From: Neil Crowther
Sent: 14 November 2014 13:01
To: Planning.Responses
Subject: FW: C14443 RE: Oldlands Farm - Surface Water Drainage Conditions BE/121/14 DOC

Subject: C14443 RE: Oldlands Farm - Surface Water Drainage Conditions BE/121/14 DOC

Further to your points raised in your email 22 October 2014 (attached for your reference) we would like to offer the following response.

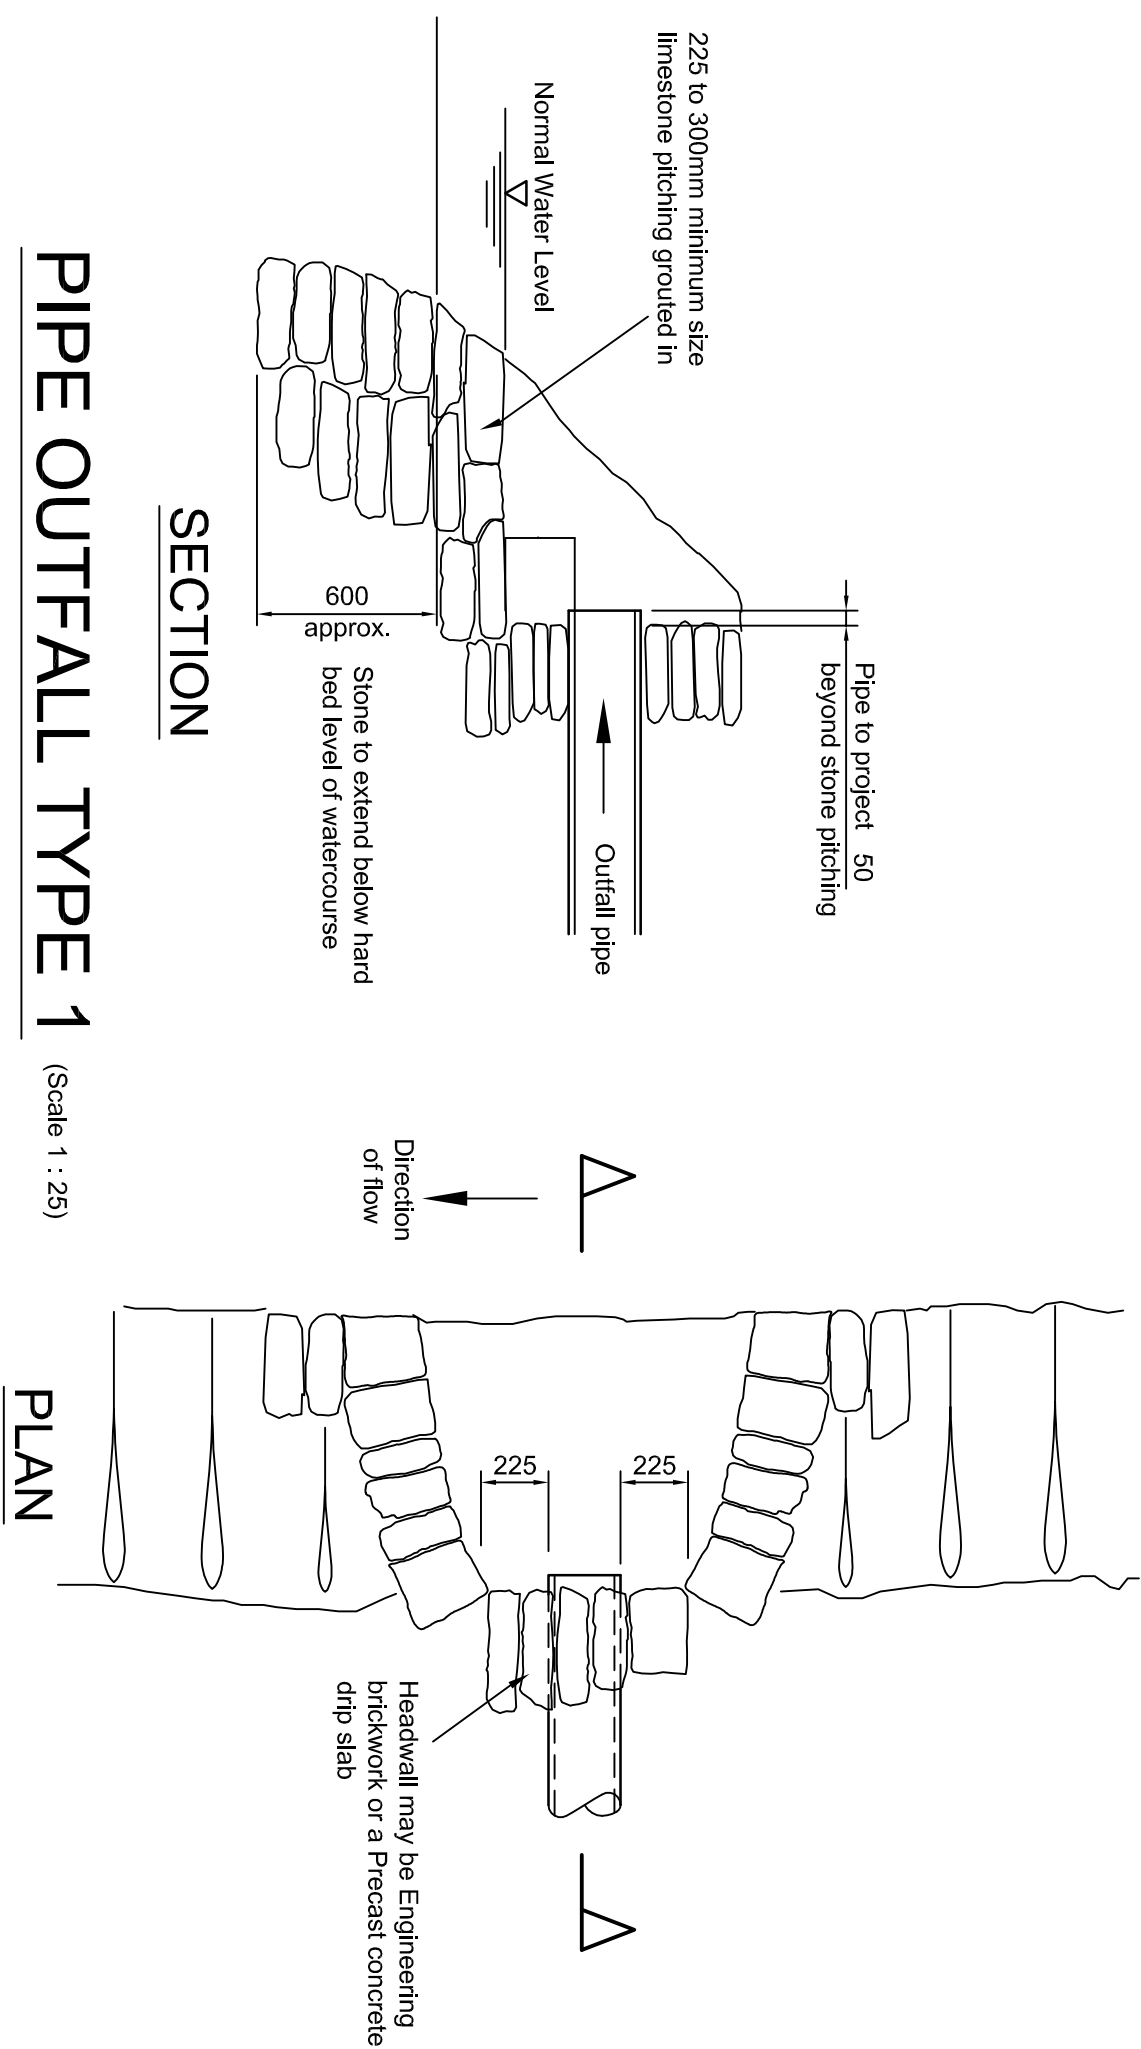
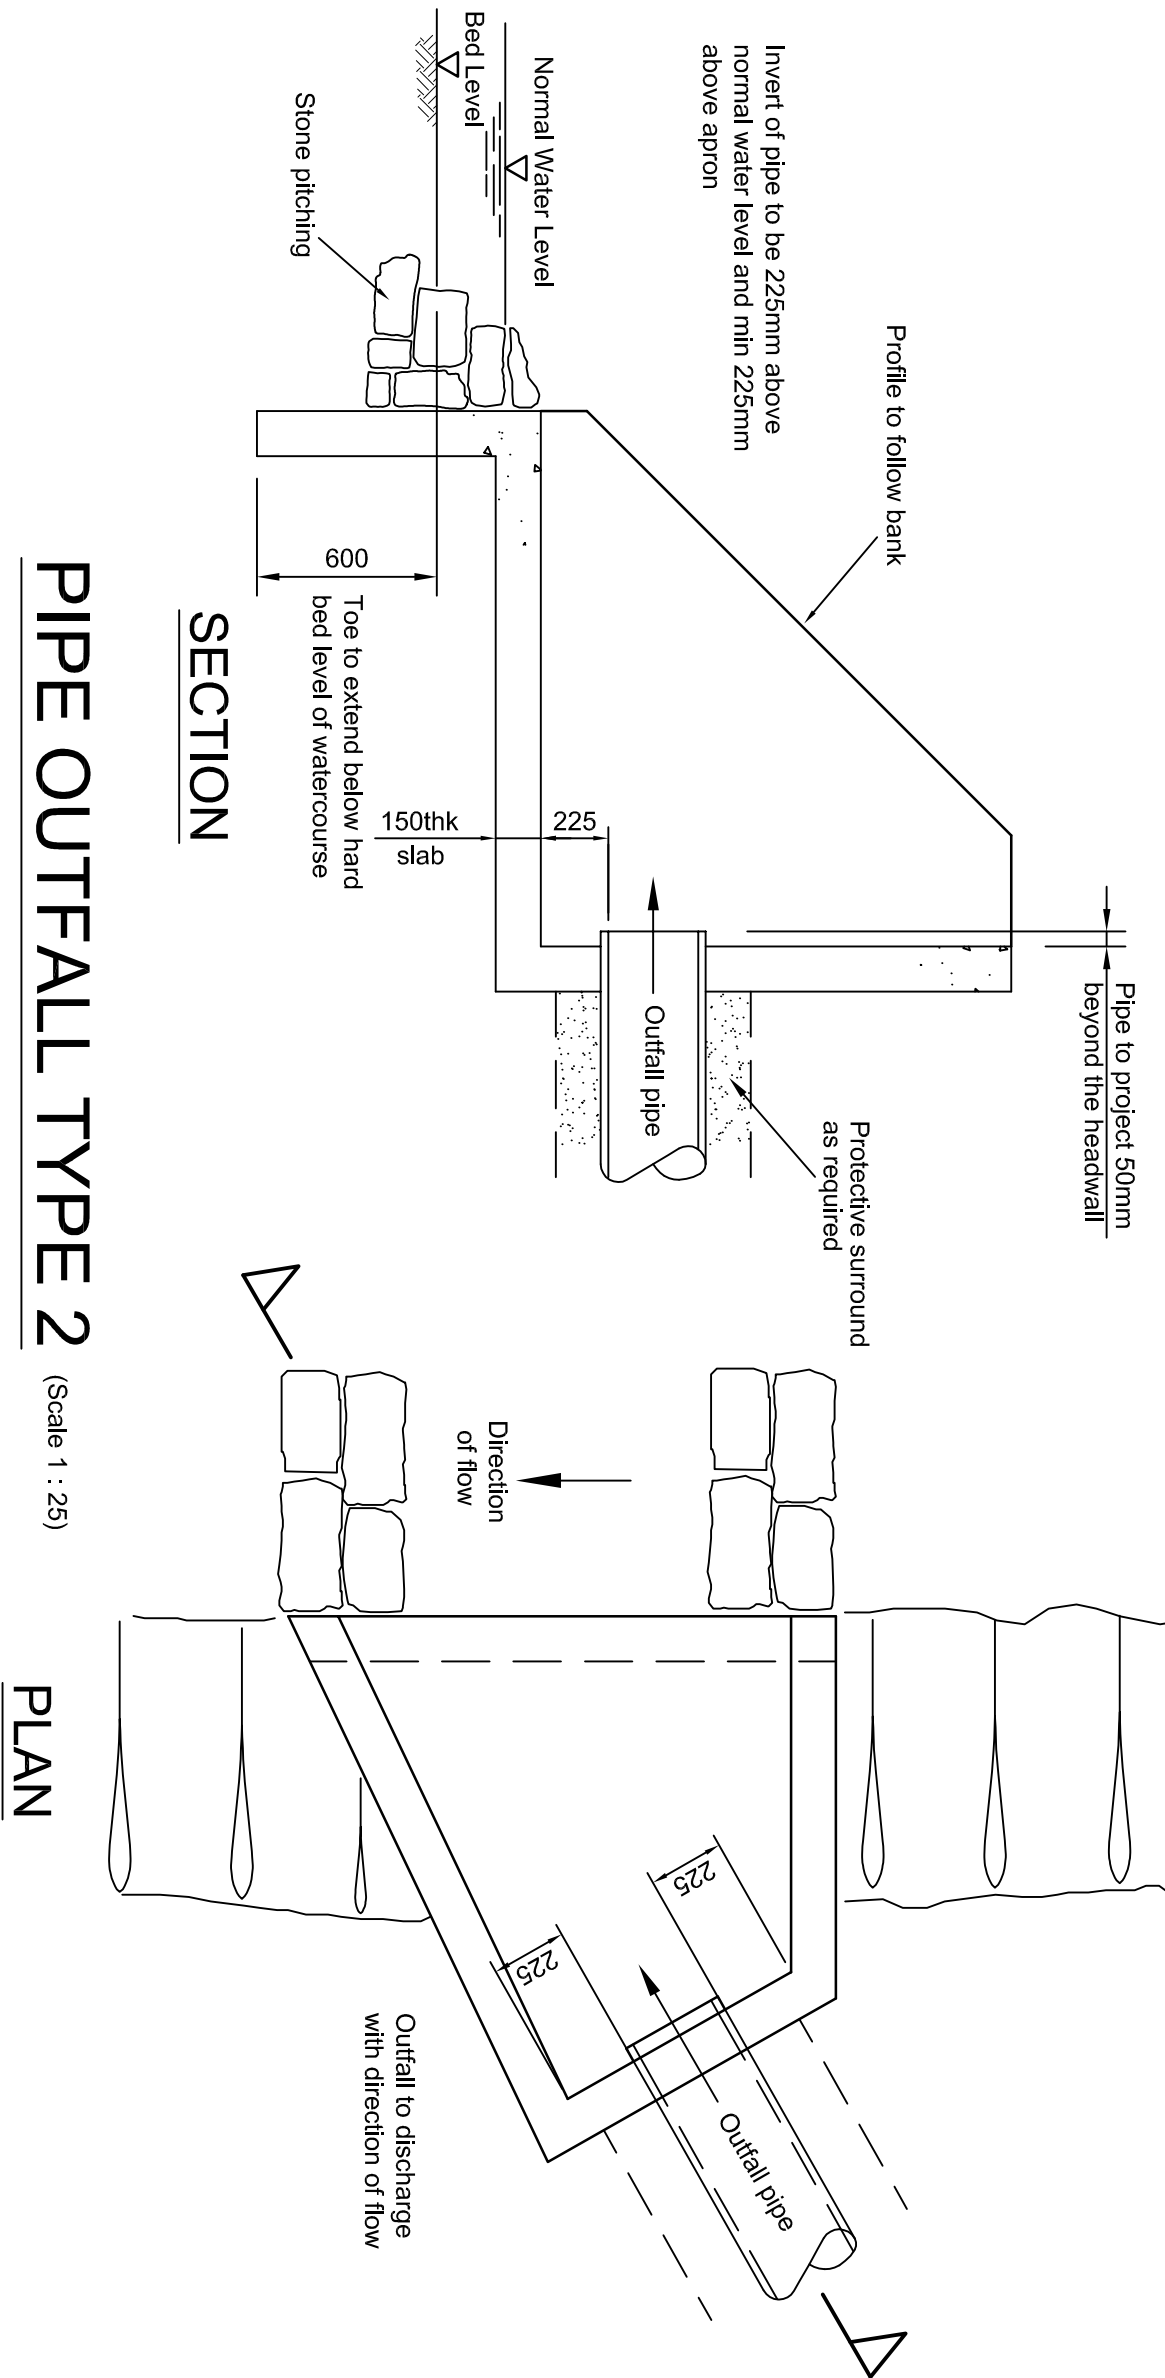
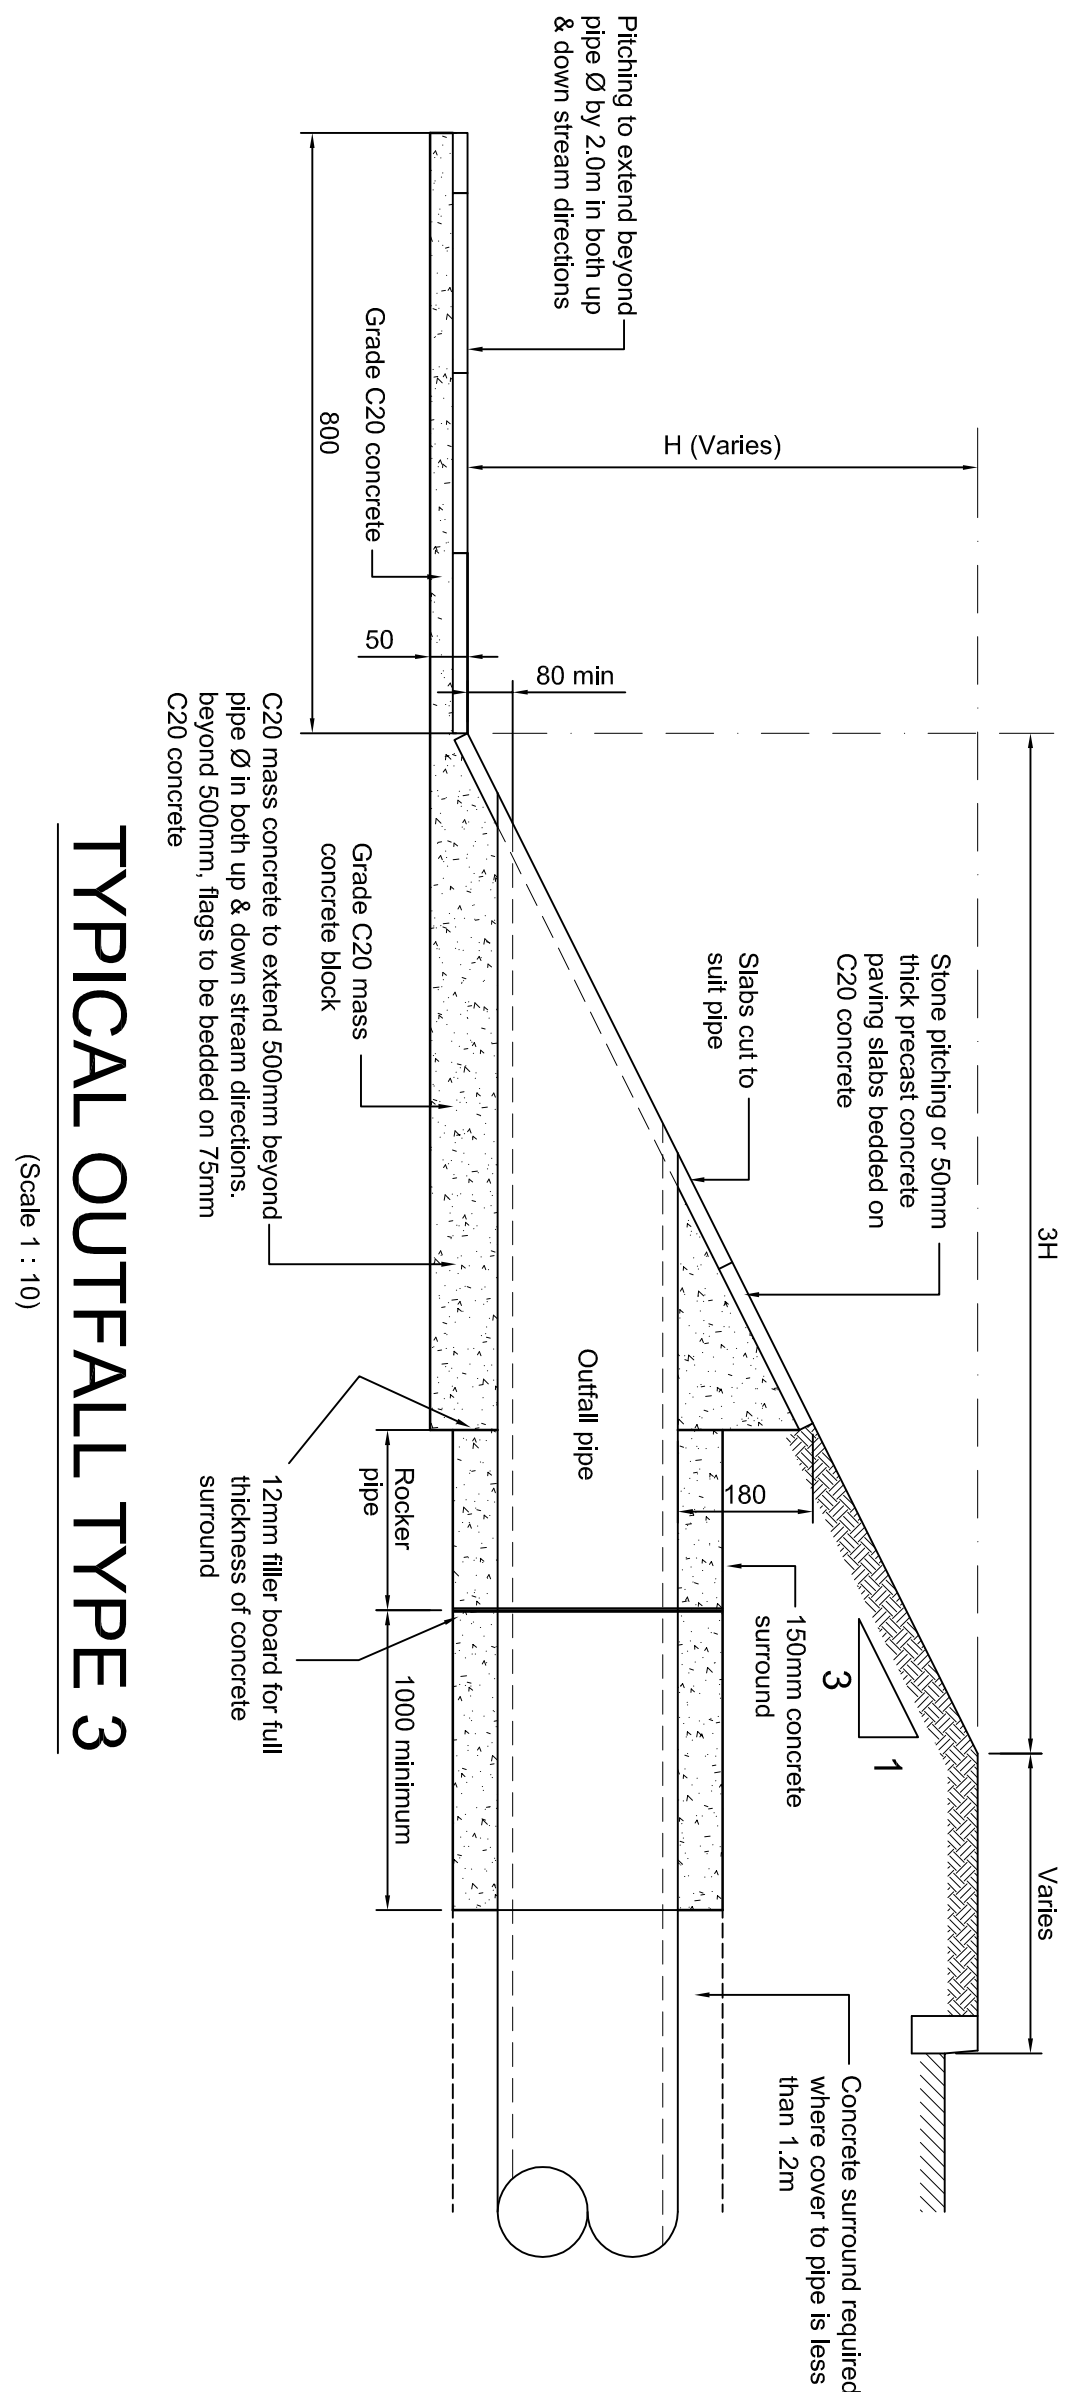
5. Outflow from pond to dry ditch has been angled further to direct flows into the channel.
6. The planning condition does not ask for construction drawings of the details you mention which will be submitted as part of the building control approval process. Drawing 220 attached gives outfall options for the contractor to price, it is likely that a precast outfall will be used. Given the nature of the ground, there will be no liner to the pond.

PLAN ON ATTENUATION POND  
Scale 1: 500

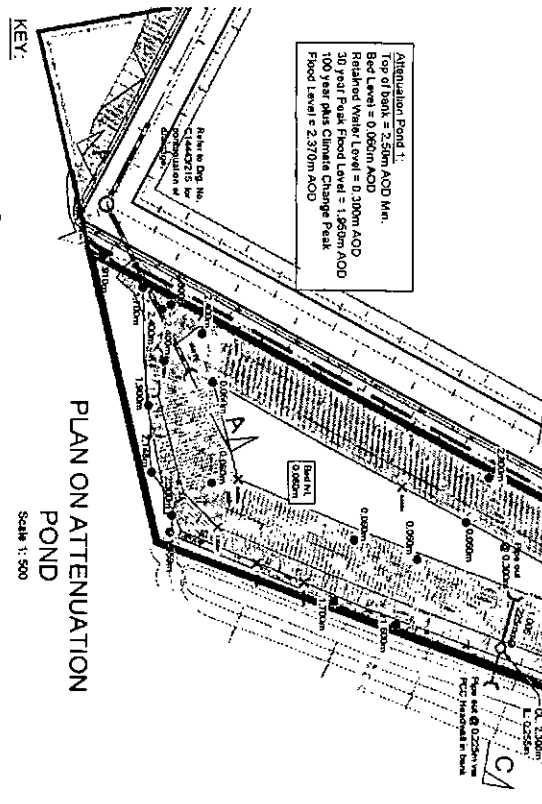
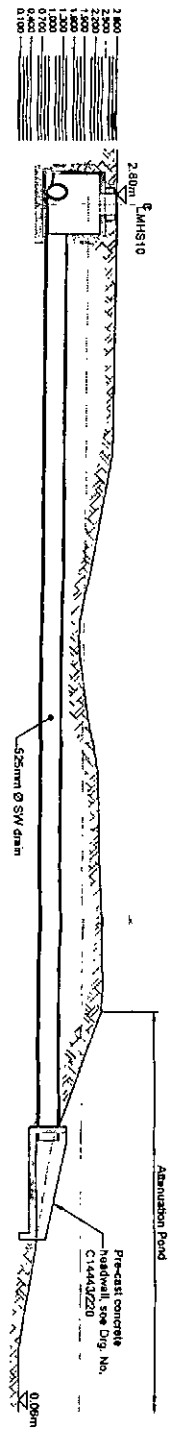
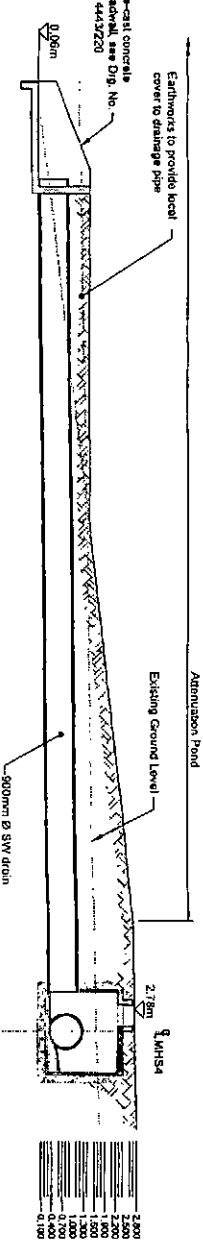
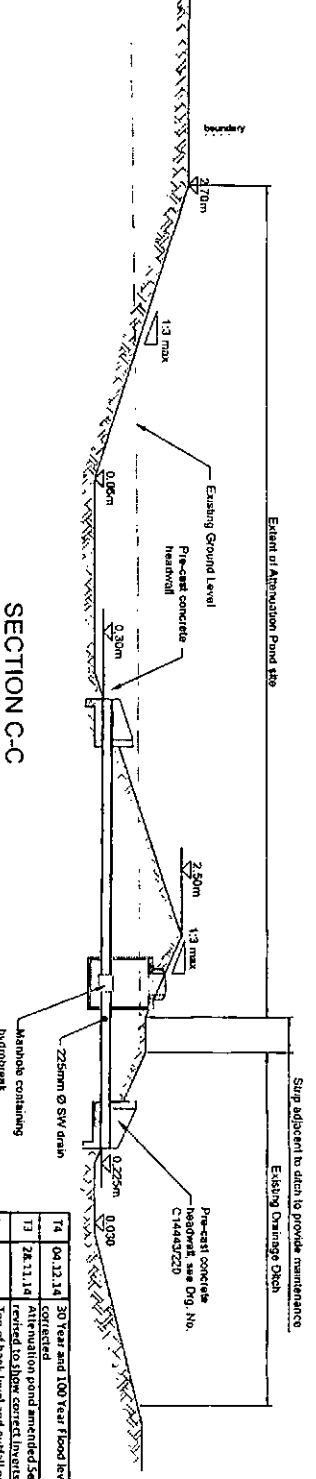
2. While we don't believe there is any guidance to support the case for 300mm freeboard. Recent re-modelling of the pond is providing the level of freeboard you would like to see. I attach the latest pond layout for reference.
